From: Kathryn <[REDACTED]>
Sent: 30 September 2019 15:39
To: Zac Denton <[REDACTED]>
Subject: Fwd: A/109/19/hh Ty Gwyn, Angmering

From: Kathryn <[REDACTED]>
Subject: A/109/19/hh Ty Gwyn, Angmering
Date: 10 September 2019 at 11:44:23 BST
To: Zac Denton <[REDACTED]>
Cc: Philip Pointon <[REDACTED]>

Its has been brought to our attention that red line for this application was slightly incorrect and included part of the neighbouring property. Please find attached the amended plans for your records, can this plans please supersede their previous versions.

PROPOSED ELEVATIONS AND BLOCK PLAN

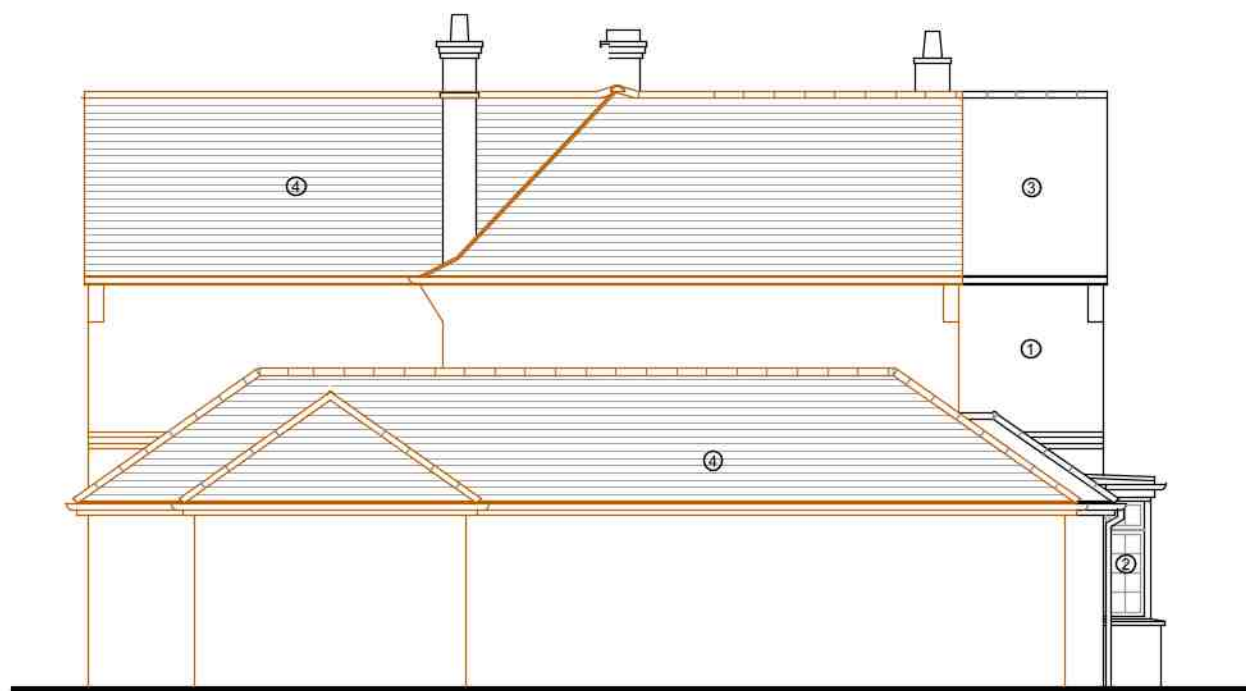
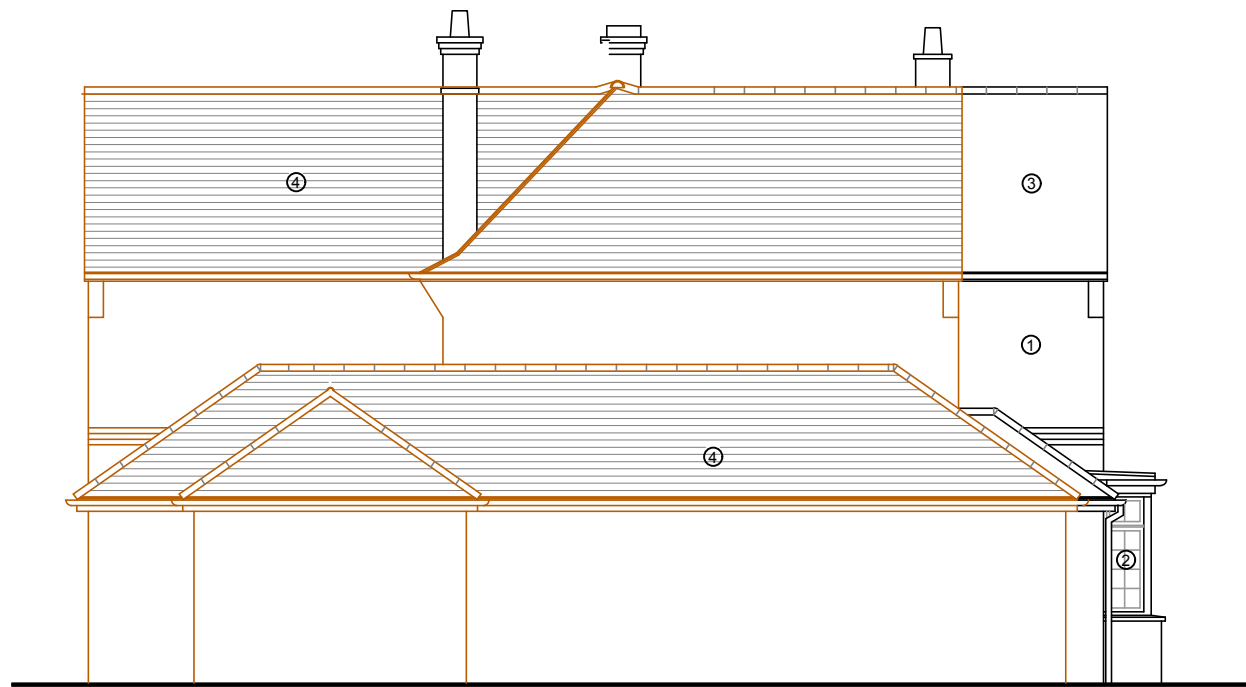
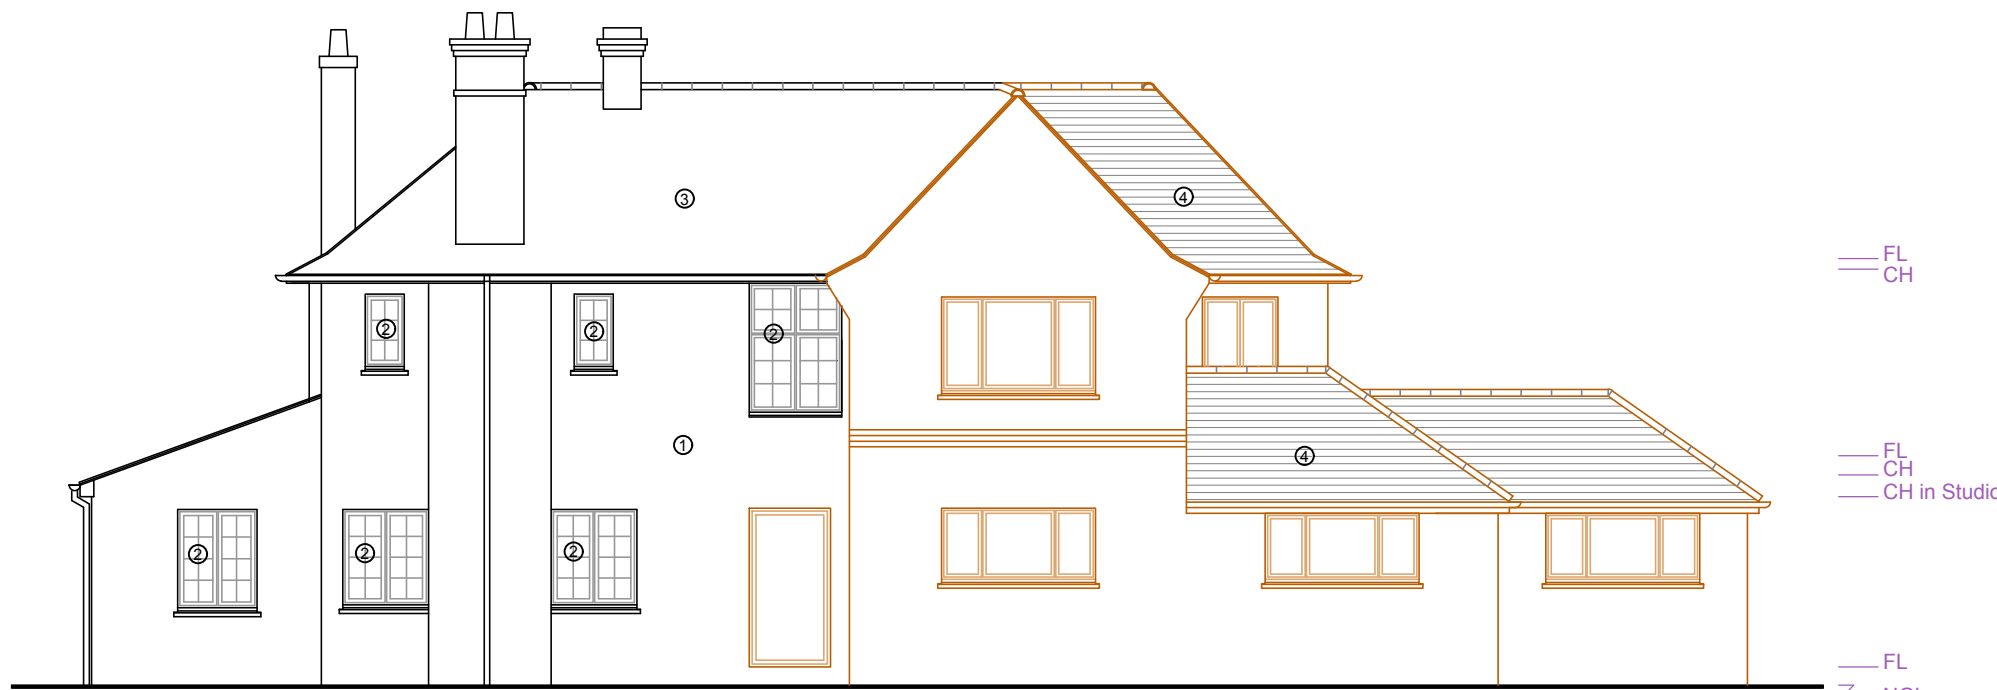
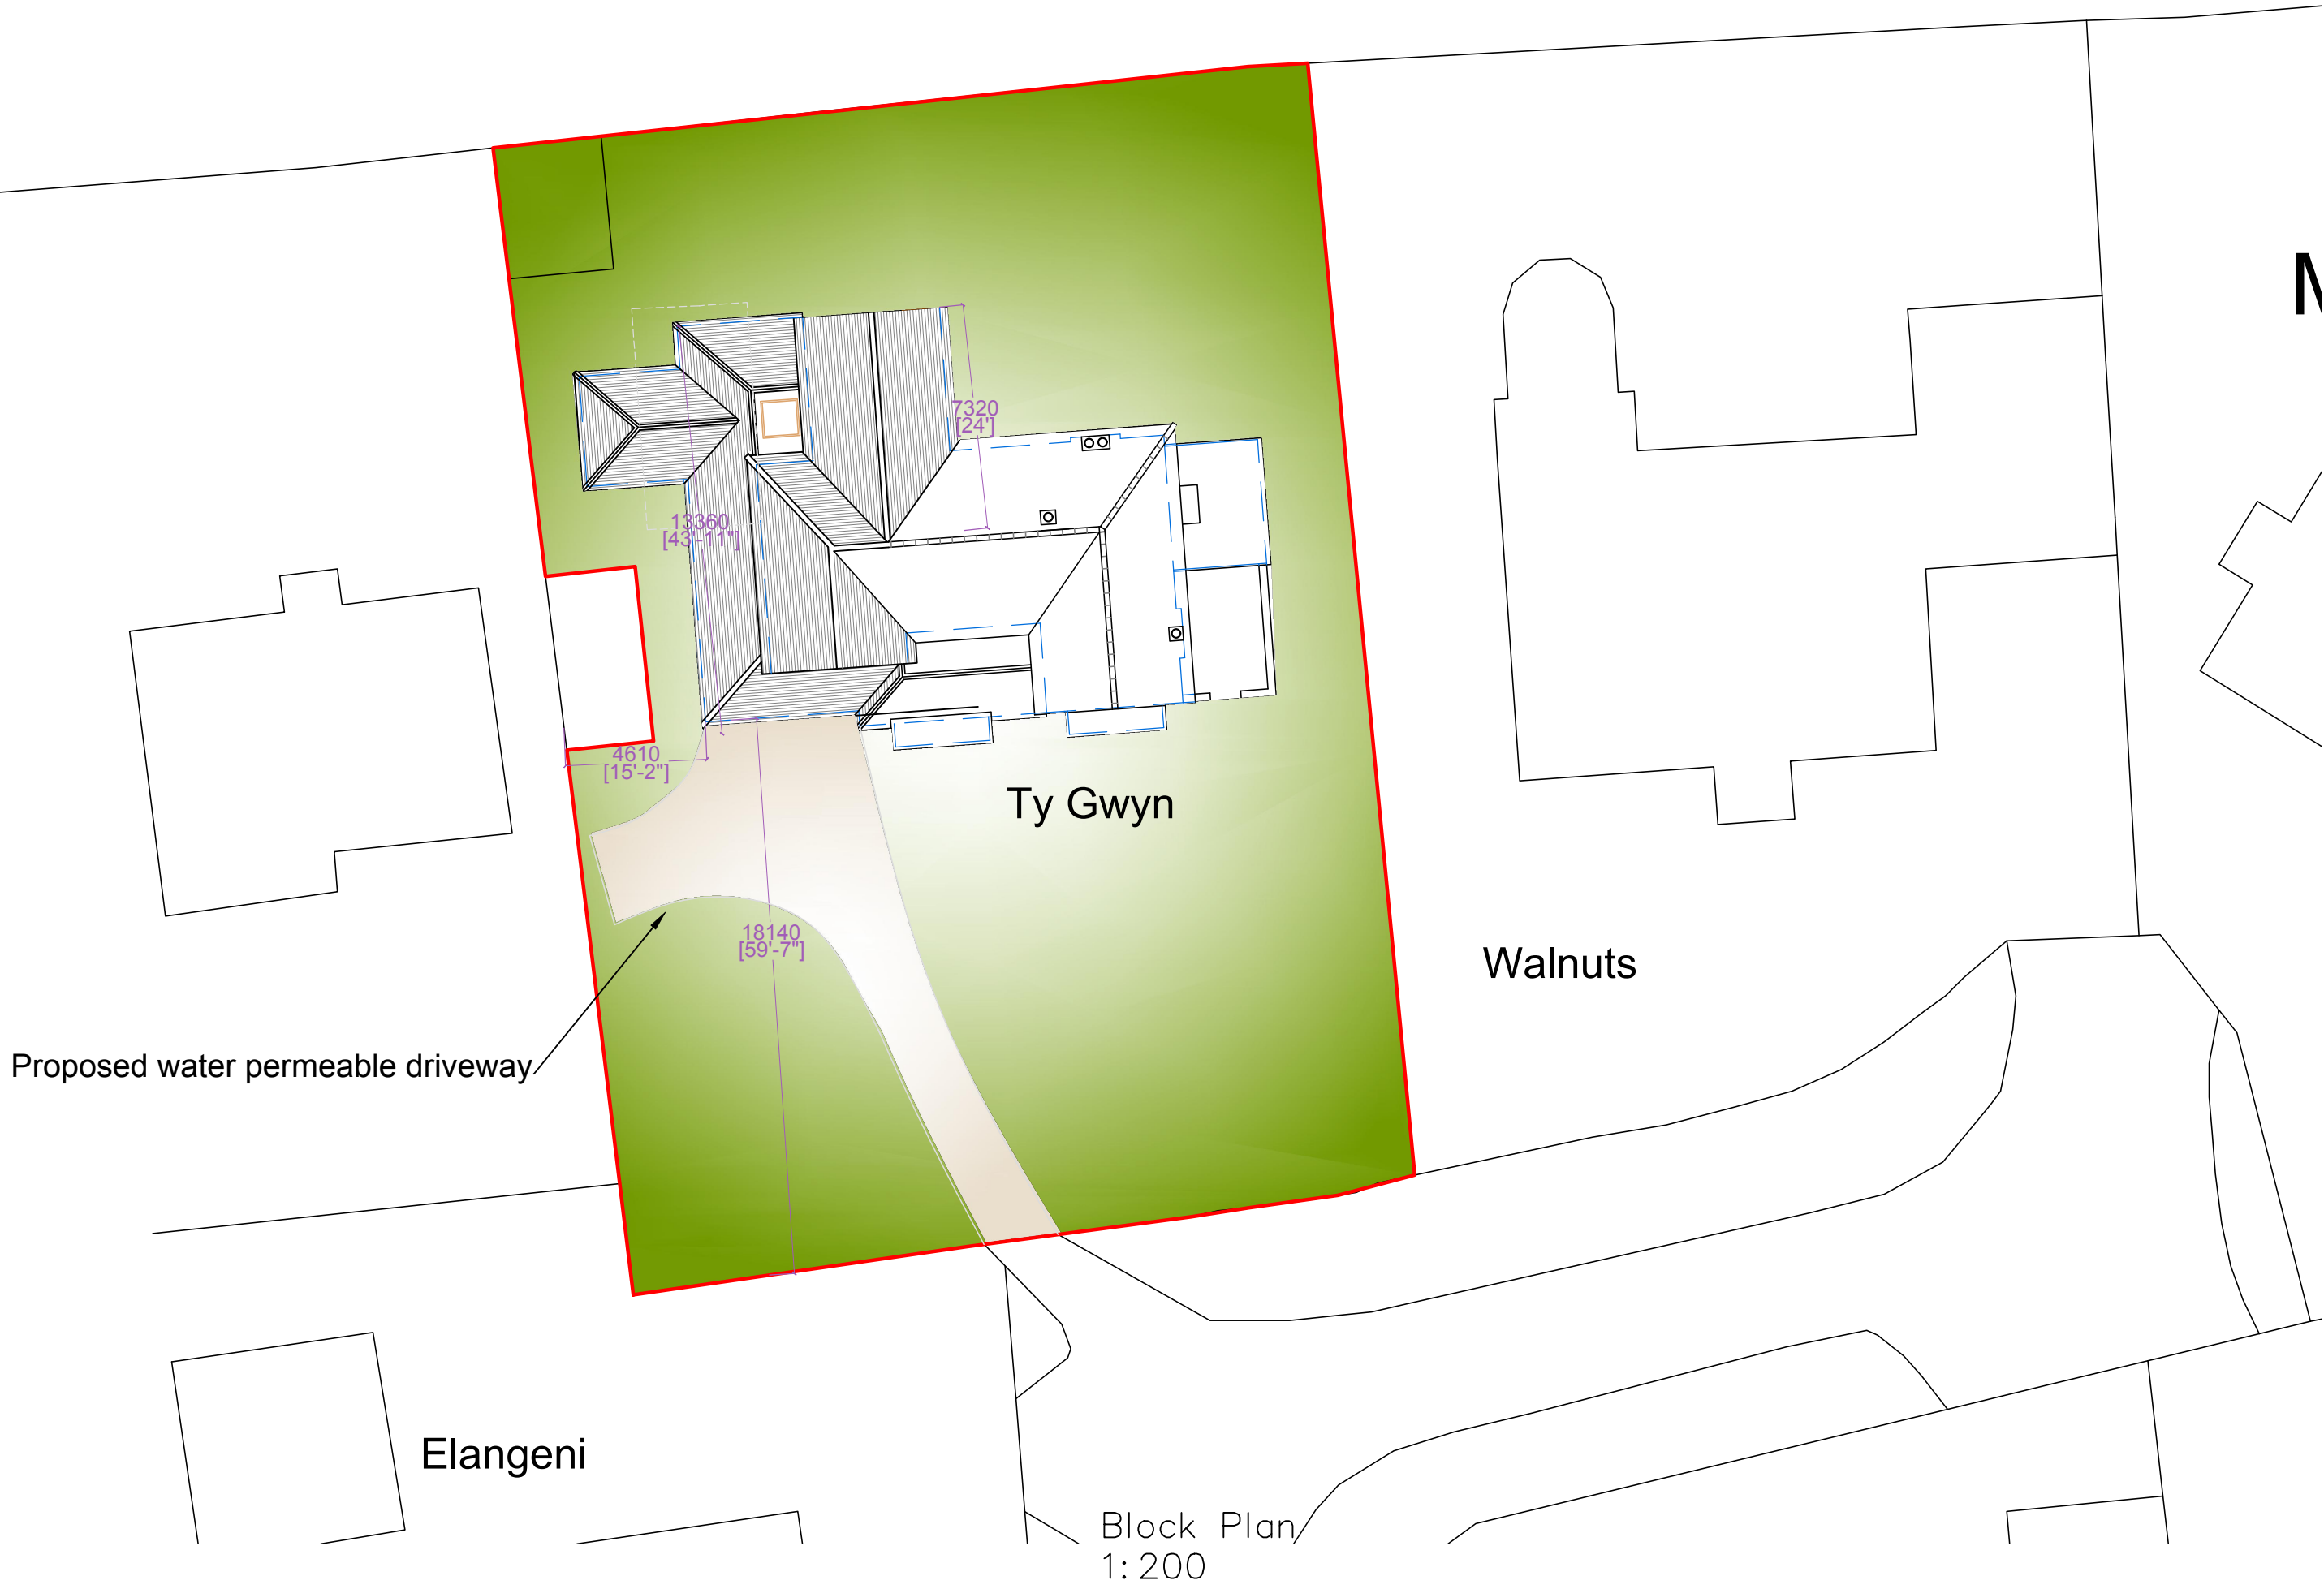
I've just been looking on the Council's website at the application for Ty Gwyn and I have noticed that the latest plans are not yet available online. I forwarded these to you on the 10th September, please see below. Could you chase this up as I see the neighbour has made comment regarding the red line area.
